Re Planning application No 3/2023/0272

In principle I have no objection to the above development. However the refuse collection for residents who live on Up Brooks is via a communal collection point as you enter on the left hand side of the road. The refuse collection wagons do not empty individual bins from individual properties. I have in the past complained to the council that in particular the general refuse bin is insufficient for the number of properties on Up Brooks as it is often overflowing. Will there be an increase in either the capacity or frequency of collections as a result of an increase in the number of properties should this development be agreed.

5765 - 16 Rev  
C

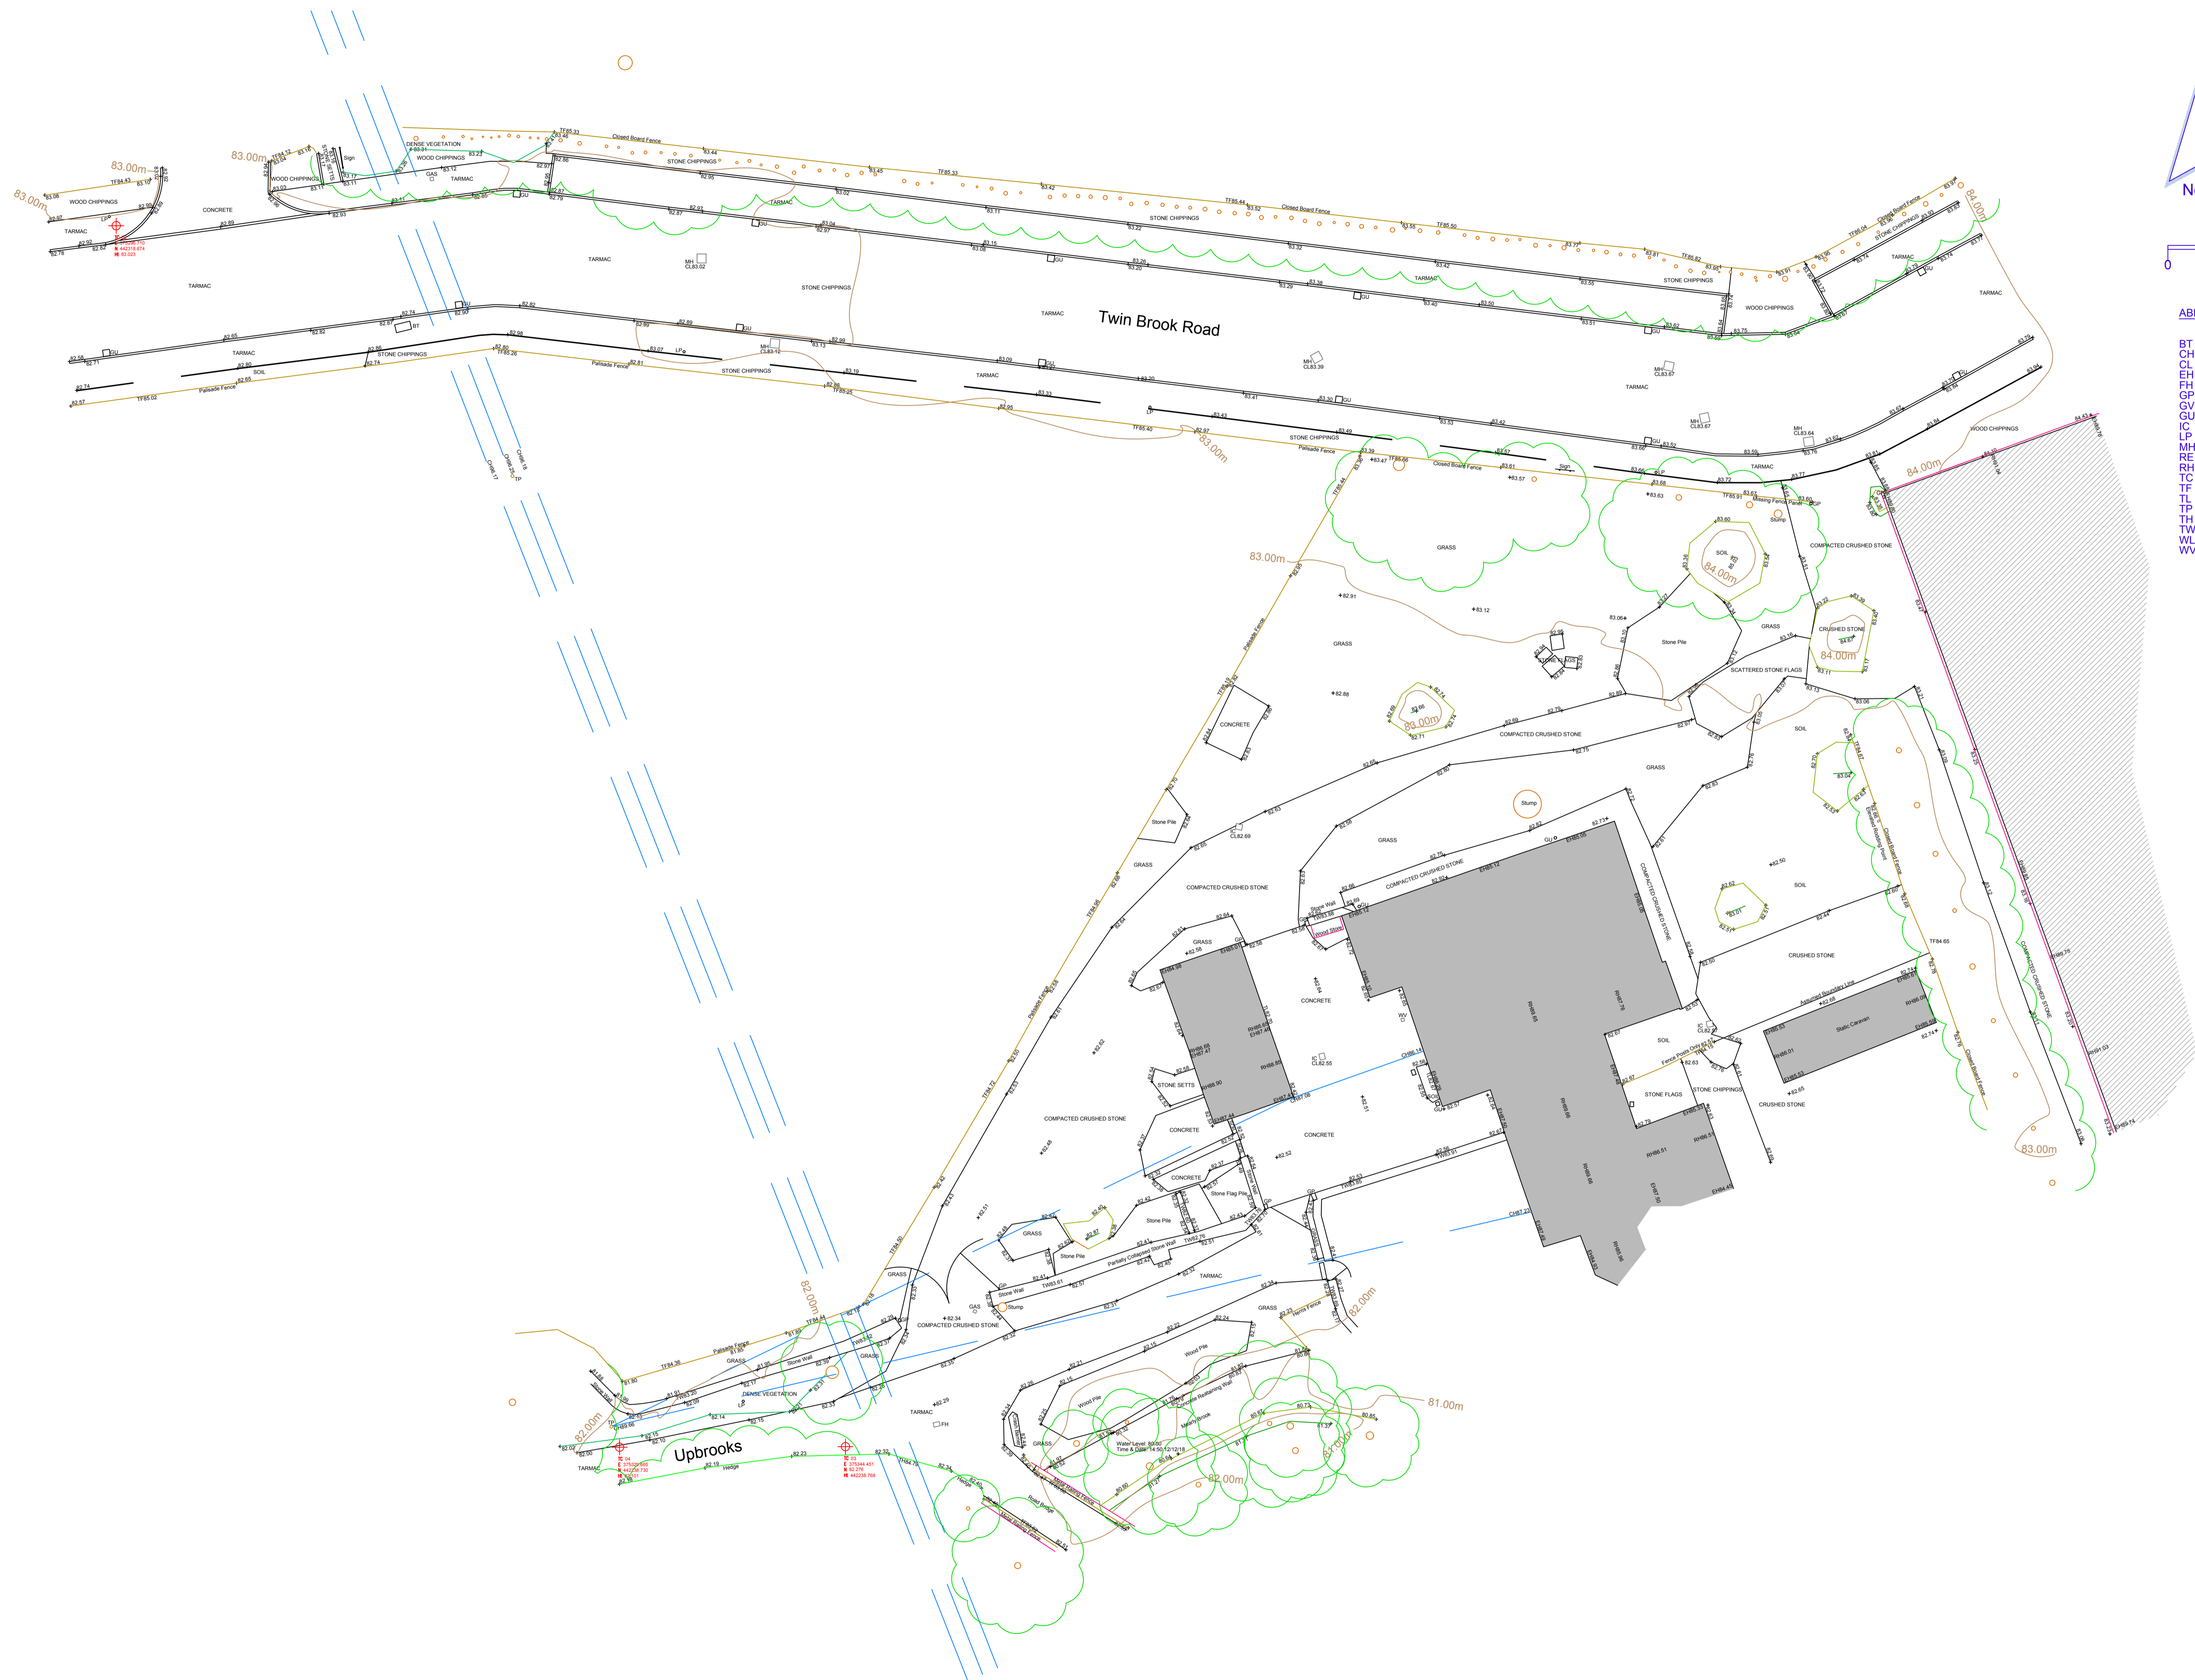
Also on the plans it shows 3 bins allocated to the new property plus at the entrance from Up Brooks to the property it states bin collection ?? is there to be a change as to how refuse is disposed off by the residents ie individual collections??
